RE: 915 Silver Ave. SW
Grading and Drainage Plan
Engineer's Stamp Date: 07/25/19
Hydrology File: K14D118

Based upon the information provided in your resubmittal received 08/02/2019, the Grading & Drainage Plan is approved for Building Permit and Grading Permit.

Re: Hydrology File #K14D118, 915 Silver Ave. SW

I have attached a revised grading & drainage plan that addresses your comments of July 19, 2019. The comments have been addressed as follows:

**C-101**

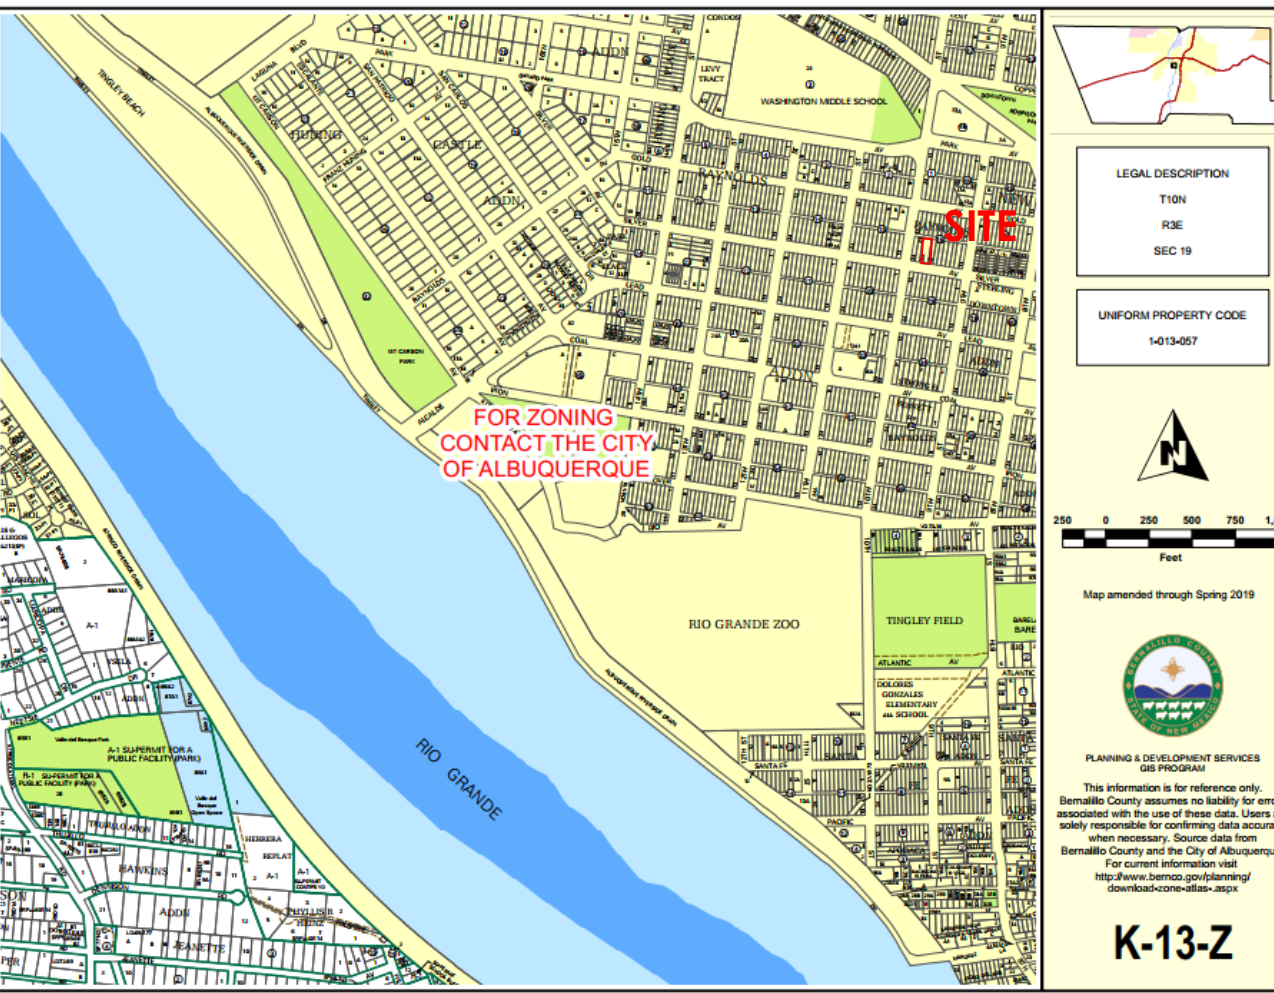
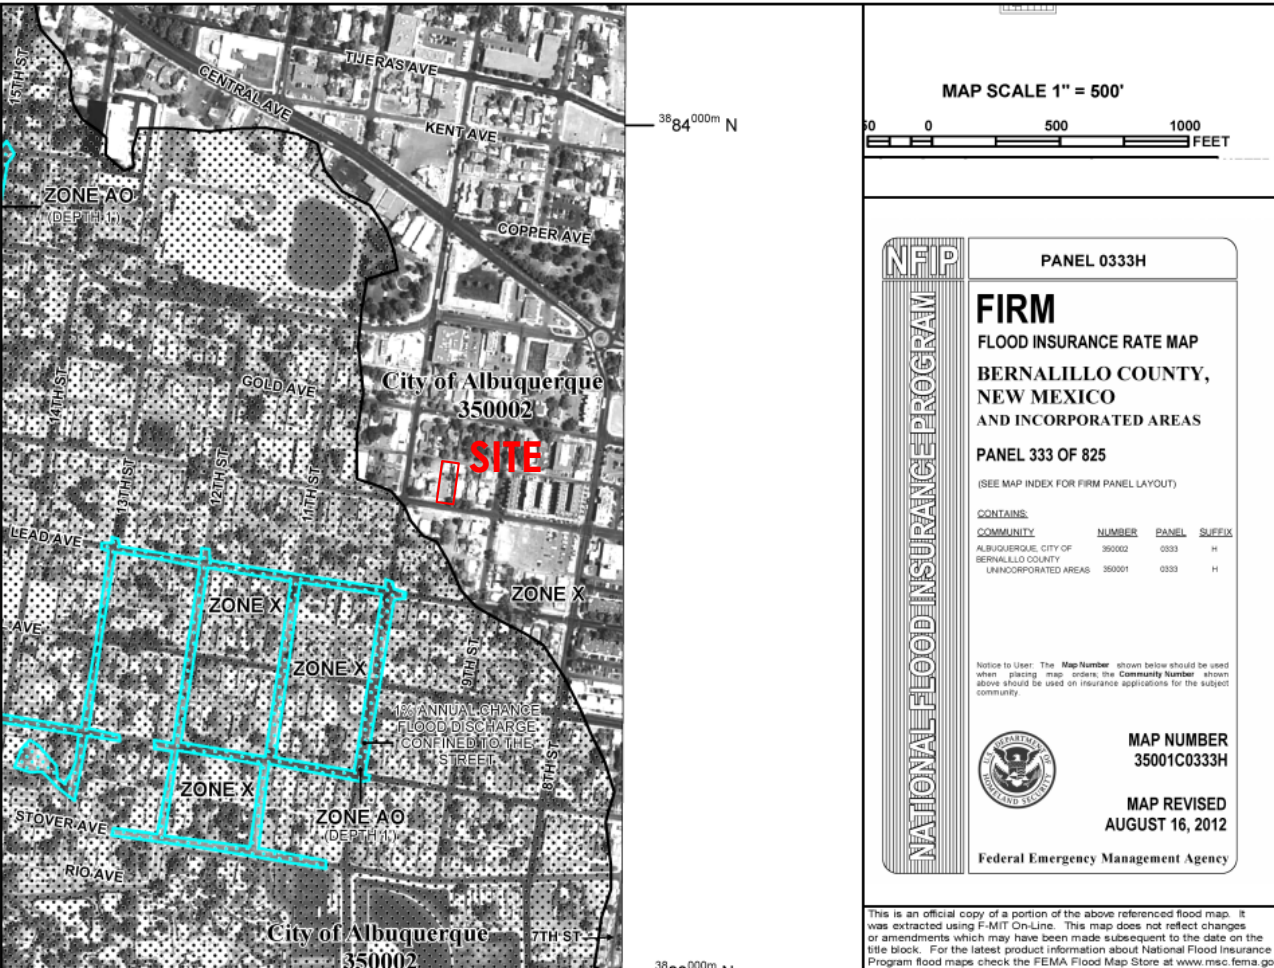
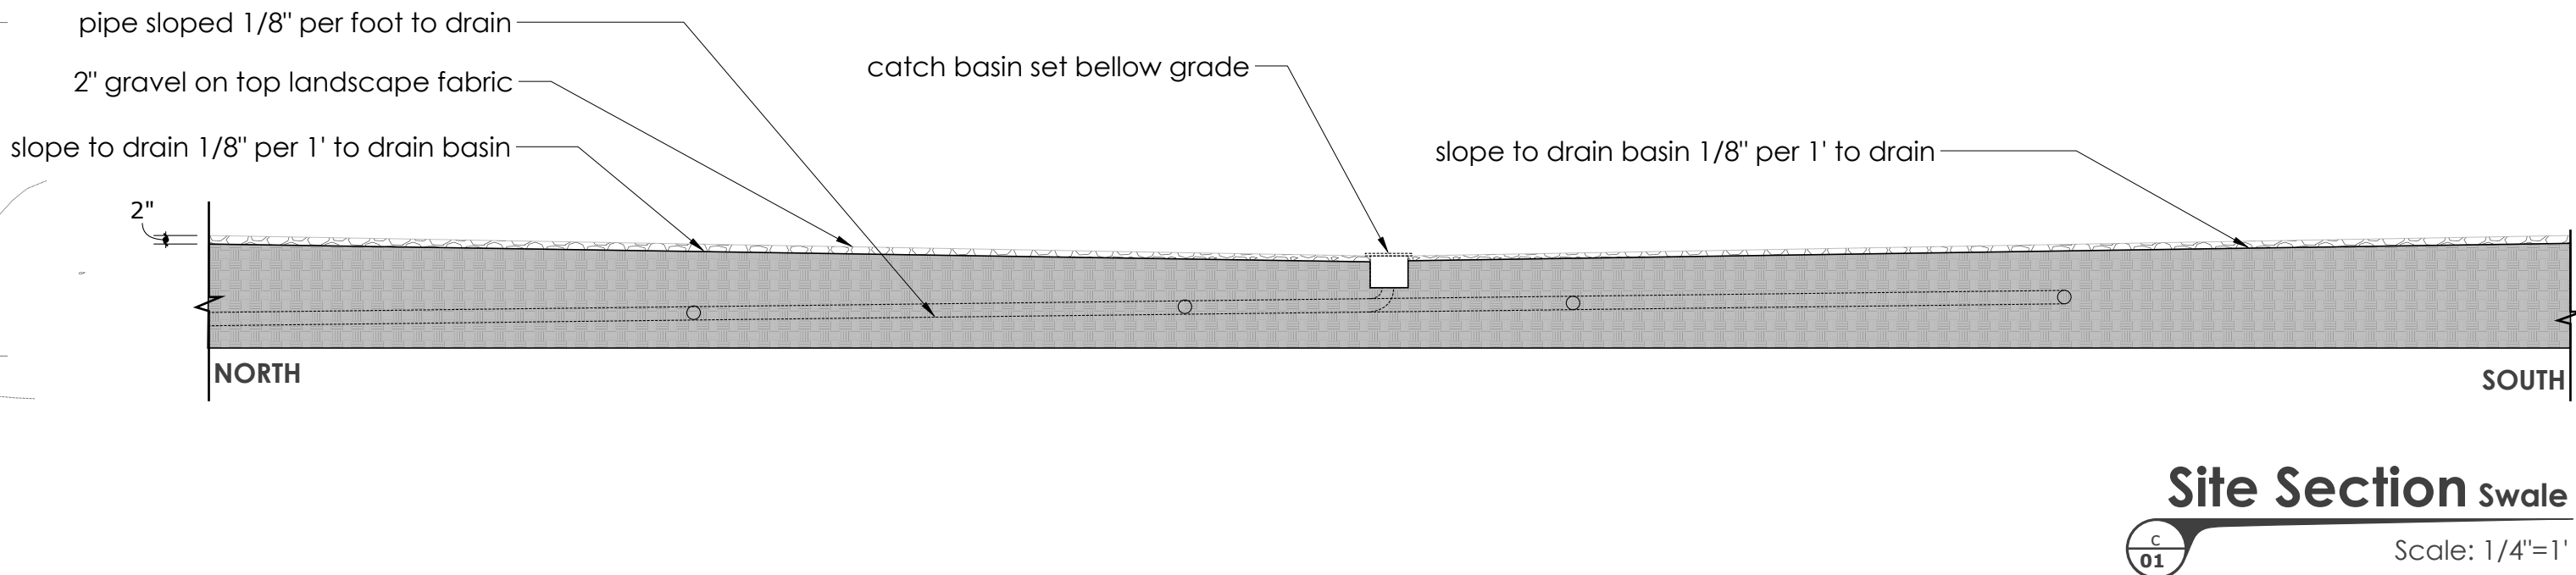
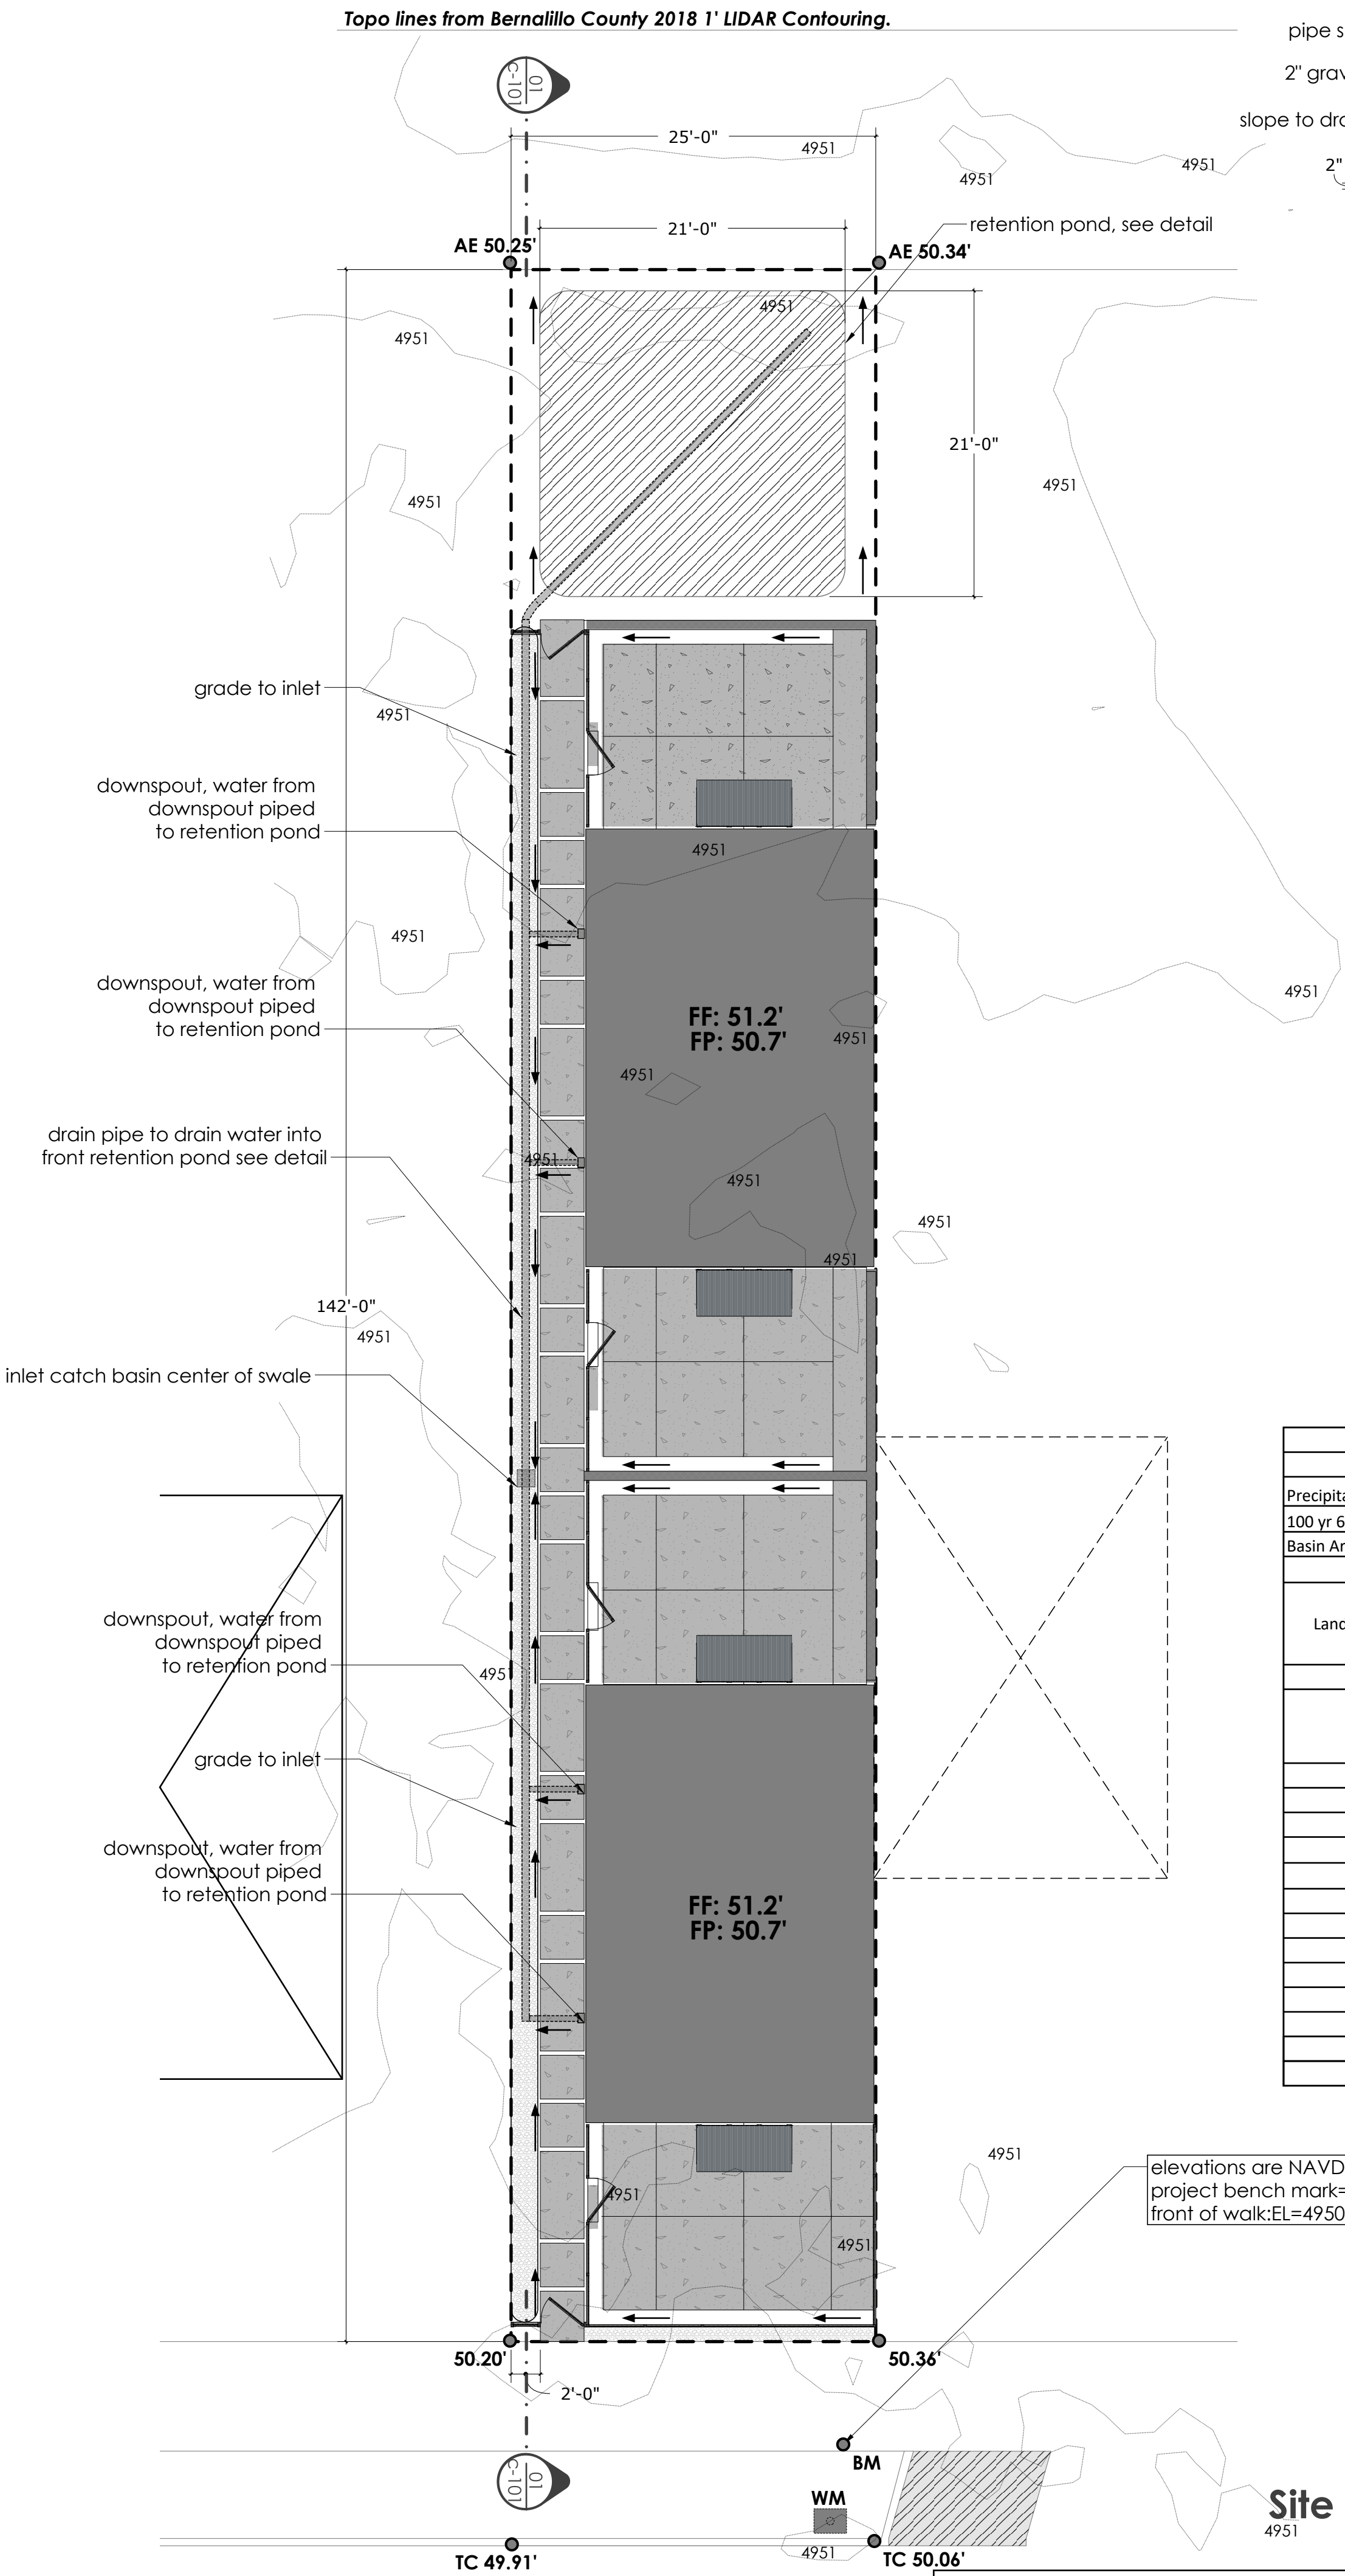
1. Even though the project benchmark is shown, please provide the City monument where this datum was taken. *The tie is presented on the plan.*
2. Per the DPM Chapter 22 Section 7 - Grading Plan Checklist, please use 1" = 20' for the scale. *The scale has been revised to 1"=20'.*

3. Per the DPM Chapter 22 Section 7 - Grading Plan Checklist, please provide a graphic scale. *A graphic scale has been provided.*
4. Please show all existing structures, fences, sidewalk, and pavement on the lot, adjacent lots, Silver R.O.W., and alley. These items are important to tie proposed grading into and are any going to remain. See aerial. *These items have been added and labeled on the plan.*

5. Please label both the alley as a "16' Public Alley" and Silver Ave SW R.O.W. *Labels have been provided.*
6. Please provide a legend showing all hatch patterns. I cannot tell what is being proposed. *Legend is provided.*

7. Please provide all dimensions needed to build the proposed retention pond especially the dimension off the property line. Also please label the retention pond. *The dimensions are now shown on the plan and labels have been provided.*

8. Please provide all dimensions needed to build the proposed French drain along the western property line especially the dimension off the property line. *An area drain pipe system is proposed in this area. It drains to the underground retention area.*

9. Please provide size of the drain pipe and proposed inlet rim elevations along with pipe inverts. *This information has been provided.*
10. Please provide the swale grades. *Spot elevations for concrete, swales and piping inverts have been provided.*

11. Since this site is in the Valley region, please follow Chapter 22 Section 5.G (Flat Grading Scheme). The following conditions must be applied to the site: *This plan proposes underground storage of the 100yr 6hr runoff volume. This was discussed with Mr. Doug Hughes prior to development of the plan.*

12. Please show how the overflow of 0.1 cfs is leaving the site from the retention pond. *The overflow location is shown on the plan.*
13. Please clarify the retention detail dimensions. Are these in inches or feet? Also please use aggregate instead of clean rounded cobble. *Dimensions have been provided. The clean rounded cobble is required to achieve the 30% porosity for the underground stormwater storage area.*

14. In the provided retention pond volume calculations, which dimensions are to be used in this project? There are five shown. *The developer has chosen the 21'x21'x4.4 configuration. This is shown on the plan.*

15. The site section does not provide any relevant information and can be removed. *The section now shows piping inverts and slopes for the proposed swale and area drain system as requested in 9 above.*
